WEST SUSSEX COUNTY COUNCIL CONSULTATION

TO:	Arun District Council FAO: Simon Davis
FROM:	WSCC - Highways Authority: Tim Townsend
DATE:	19th March 2021
LOCATION:	Clays Farm North End Road Yapton BN18 0DT
SUBJECT:	Y/18/21/RES Approval of reserved matters following Y/62/18/OUT for 33 No. residential units, access, landscaping & associated works. This site is in CIL Zone 3 & is CIL Liable as new dwellings.
DATE OF SITE VISIT:	n/a (desktop assessment)
RECOMMENDATION:	More Information Required
S106 CONTRIBUTION TOTAL:	n/a for purposes of this application

ACCESS ROAD LAYOUT

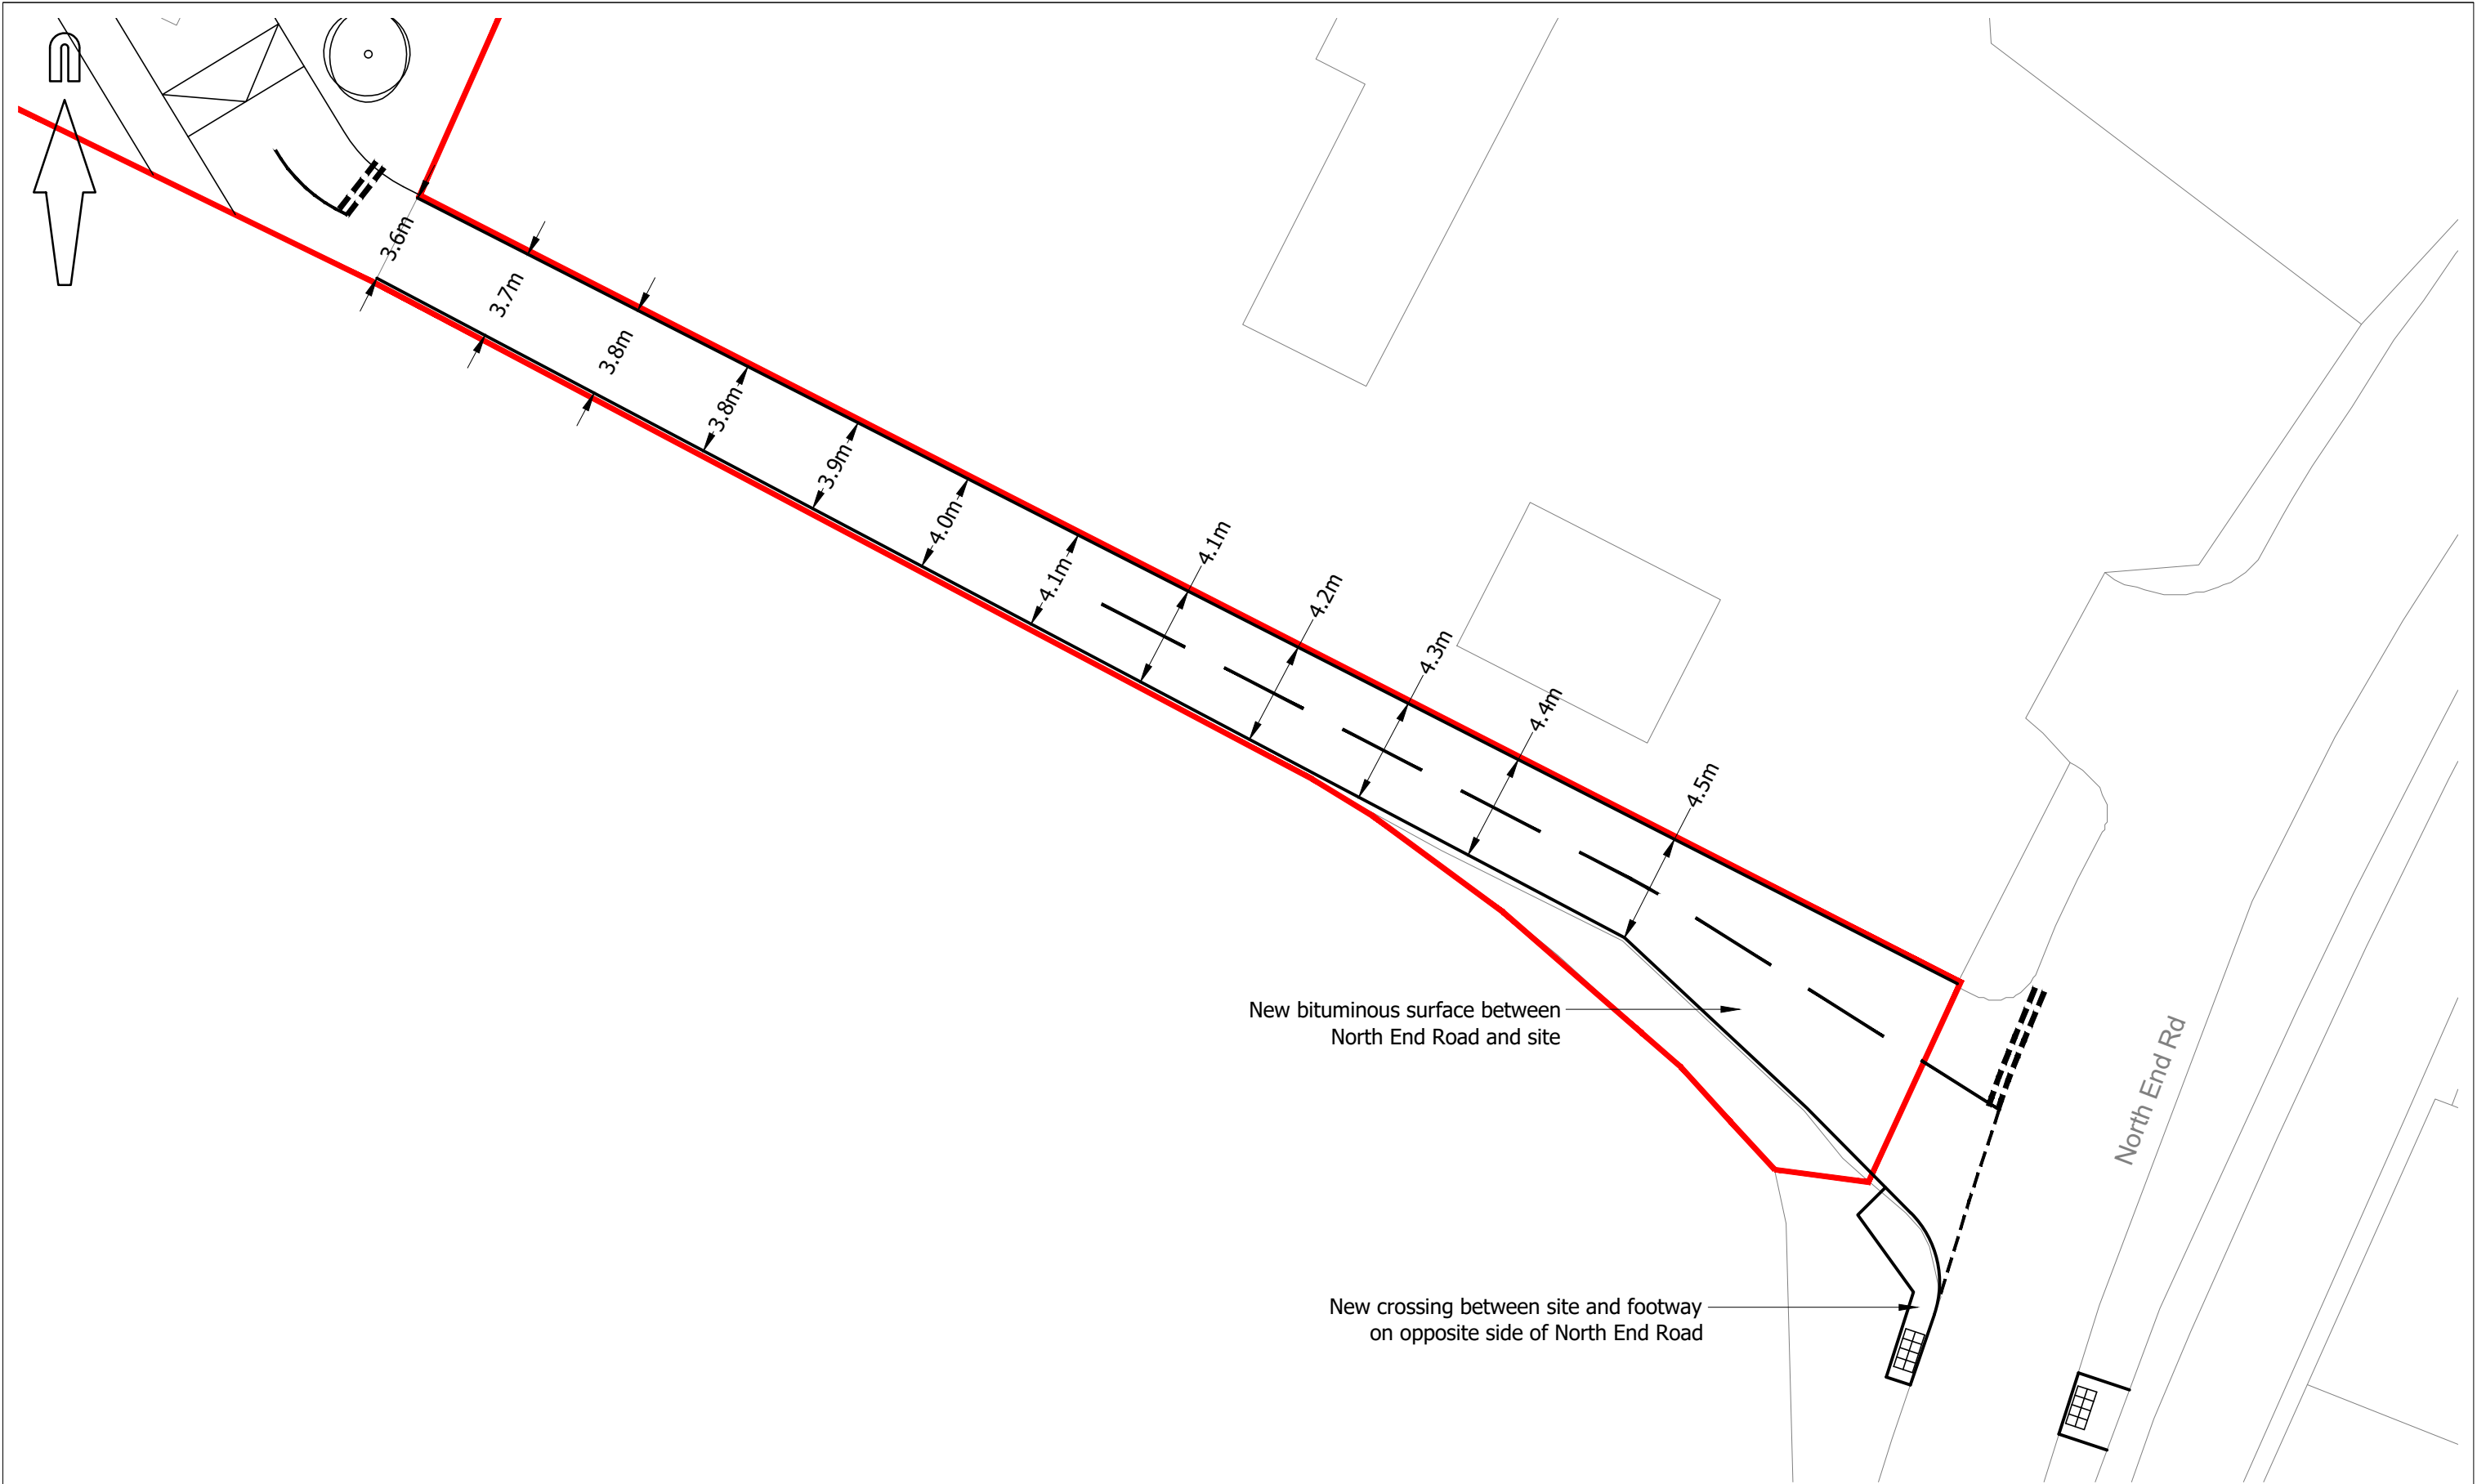
1. A detailed plan showing the section of access road from North End Road up to the start of the internal site layout. Please also provide the Road Safety Audit carried out for that section of road. This is required to show how it and the internal layout are proposed to work together.
2. The internal road layout as currently should would, in places, give a 'mixed-message' to users with regard to shared space and traditional footways and carriageway given lack of footways in one general area (north-western side of the main section of internal access road). It is recommended that a footway is provided on this side as well as the other – additional section as indicated on the extract below (see red dots):
